ADVICE ON ENVIRONMENTAL IMPACT ASSESSMENT (EIS) – STATE SIGNIFICANT DEVELOPMENT – ROUSELL ROAD WAREHOUSE AND DISTRIBUTION CENTRE (SSD-41807966) (BLACKTOWN)

The following provides for Fairfield City Council's submission in relation to the above proposal.

Irrigation Zone Plan

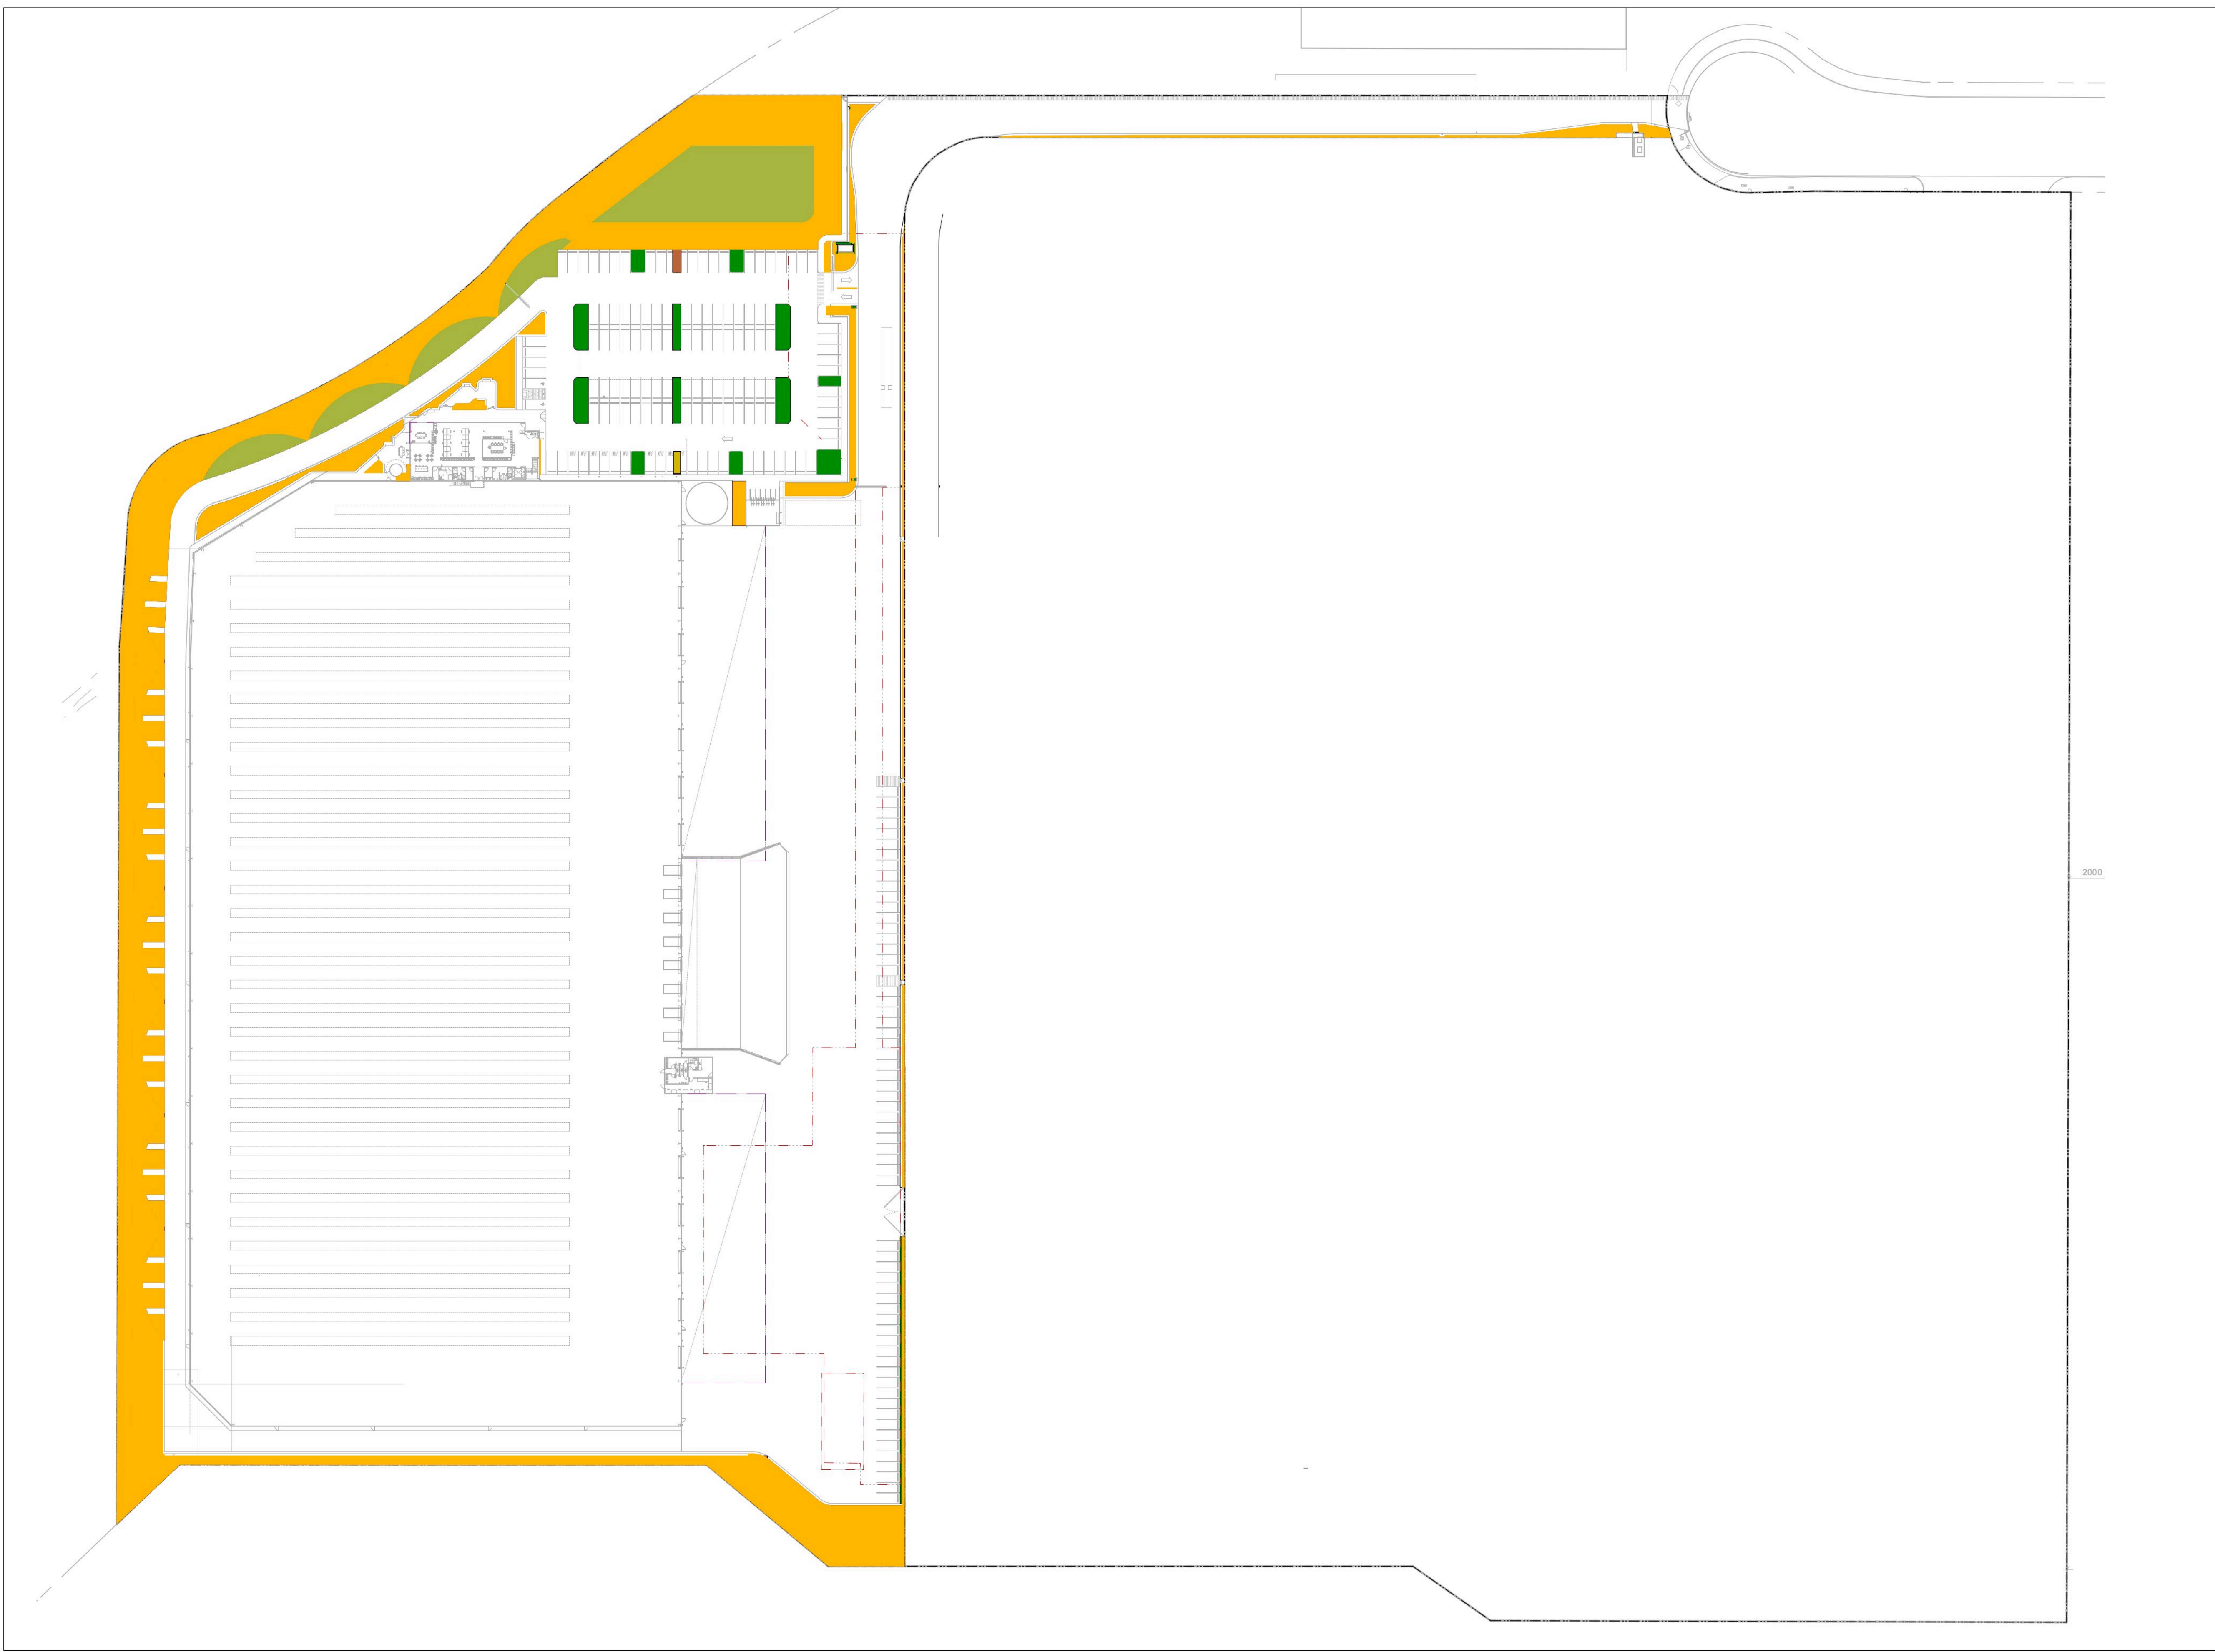
- 1. Setback to Reedy Creek & light pollution** – It is unclear from the landscape plans what the setback is to the Reedy Creek corridor, this is to be confirmed by the applicant. Lighting is proposed to be provided within this setback that has the potential generate negative impacts on nocturnal fauna within the Reedy Creek corridor. To address this the SSDA shall be conditioned to provide for National Light Pollution Guidelines for wildlife, see link below.

- 2. Landscape Plan** – Due to the proximity to nearby or adjacent natural bushland areas, an amended landscape plan is to be provided to Blacktown City Council that ensures nursery hybrids of locally occurring native species are not planted within 100 metres of natural areas. The landscape plan is to avoid species that are invasive; including native species for example Indian Hawthorn, Gazania, Nandina domestica and Pennisetum.
